Lime Down

Solar Park

Statement of Common Ground with Environment Agency (Clean)

Planning Inspectorate Reference: EN010168

Title:
Figure 11.3 Rev 4: Lime Down C1 Fluvial
and Surface Water Flood Risk Map

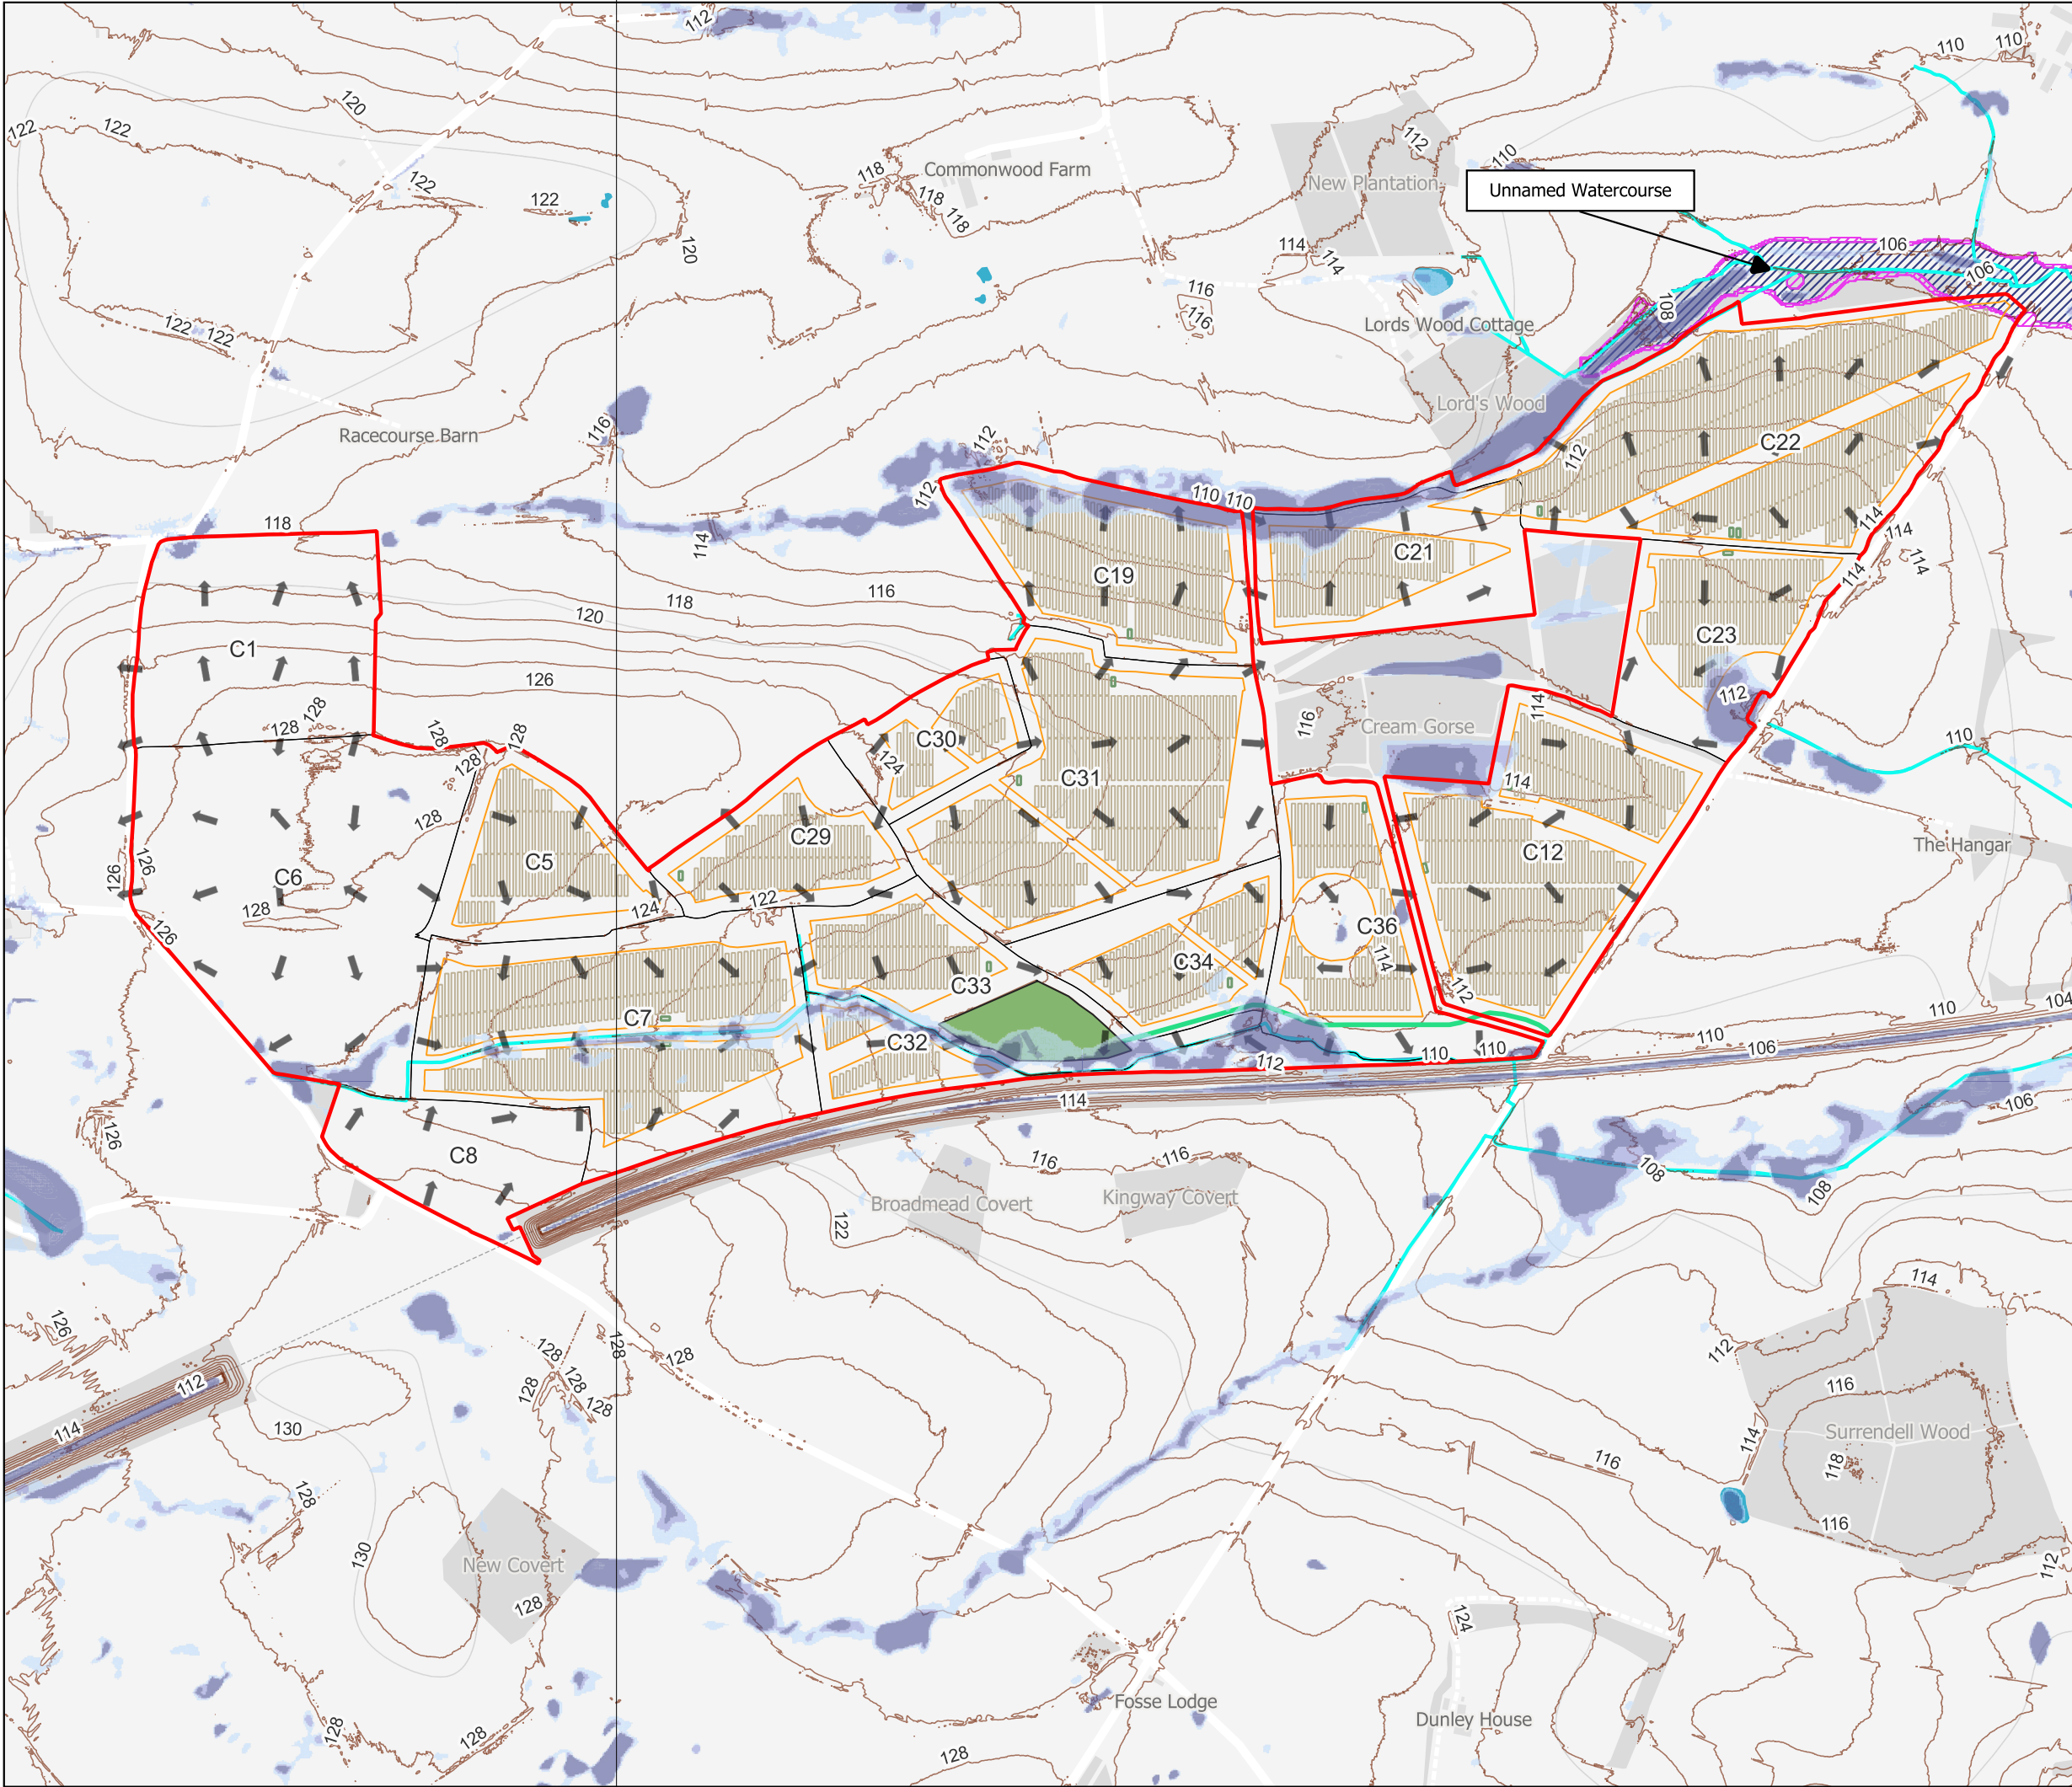
Reference	Sub-topic	EA Position	Applicants Position	Status
		If it is not possible to place the substation within Lime Down C1 outside of the mapped flood flow routes, further assessment will be undertaken at detailed design to determine if the placement of the substation within Lime Down C1 would increase flood risk elsewhere. If there is an increase to flood risk elsewhere, floodplain compensation will be provided, in consultation with the Environment Agency, to ensure that there is no increase in flood risk. Engagement with the EA will occur throughout the detailed design stage on the need, method of calculating volumes, modelling and design of any floodplain compensation that may be required.	EA-049 in Applicant's Response to Comments Received at Deadline 2 [REP3-129]. The separate point raised by the Environment Agency in relation to the potential placement of the Lime Down C1 substation within mapped flood flow routes is addressed below. Interaction with the floodplain has been avoided where practicable through layout design. Where limited interaction remains, the Applicant has assessed displacement from the proposed solar panel supports using a deliberately conservative methodology. The assessment assumes displacement is redistributed only across the modelled flood extent within the relevant Lime Down site boundary, rather than across the wider hydraulically connected floodplain. This is precautionary, as in practice any displaced floodwater would be distributed over a substantially larger floodplain area. For Lime Down D, the assessment identifies a displaced volume of 11.59m³, redistributed across an on-

Reference	Sub-topic	EA Position	Applicants Position	Status
			site modelled flood extent of 222,530m². This results in a theoretical increase in flood level of approximately 0.000052m. For Lime Down E2, the assessment identifies a displaced volume of 2.09m³, redistributed across an on-site flood extent of 50,735m². This results in a theoretical increase in flood level of approximately 0.000041m. In both cases, the calculated increase is de minimis, several orders of magnitude below the precision at which flood levels can be meaningfully defined, and would not result in any measurable change to flood levels, flood extents, flow routes or flood risk to third parties. The revised assessments also include figures showing the flood extent and displacement calculation areas for Lime Down D and Lime Down E2. The Applicant therefore considers that the assessment demonstrates flood risk neutrality and that compensatory flood storage is not necessary or proportionate. The Environment Agency has confirmed that the

Reference	Sub-topic	EA Position	Applicants Position	Status
			Applicant has provided sufficient evidence to demonstrate that loss of floodplain storage would be negligible in the context of Gauze Brook and Gabriel's Well / Rodbourne Brook. In relation to Lime Down C1, the Applicant will continue to engage with the Environment Agency through detailed design on the siting of the substation, the need for any further flood risk assessment, and the method and design of any floodplain compensation or other mitigation that may be required. Any residual matter relating to the delineation or application of Flood Zone 3b is addressed separately under row 3.3.17. For Lime Down C1, the Applicant confirms that the 132 kV substation location remains subject to detailed design. The detailed design will first seek to locate the substation outside the mapped flood flow routes identified within Lime Down C1. If this is not practicable, a site-specific assessment will be undertaken at detailed design

Reference	Sub-topic	EA Position	Applicants Position	Status
			to confirm whether the substation would alter existing flood flow routes, displace flood storage or increase flood risk elsewhere. Where the assessment identifies a requirement for mitigation, this would be developed in consultation with the Environment Agency and may include floodplain compensation, localised level adjustments, conveyance measures or other design measures as necessary to ensure no increase in flood risk elsewhere. This is set out in FRA Appendix 11-6: Lime Down D / BESS [REP3-056], paragraphs 2.3.23 to 2.3.29 and Figure 8, FRA Appendix 11-8: Lime Down E2 [REP3-061], paragraphs 2.3.16 to 2.3.21 and Figure 8, and the wider ES Volume 3, Appendices 11-1 to 11-9: Flood Risk Assessment and Drainage Strategy [REP3-039, REP3-49 to REP3-064].
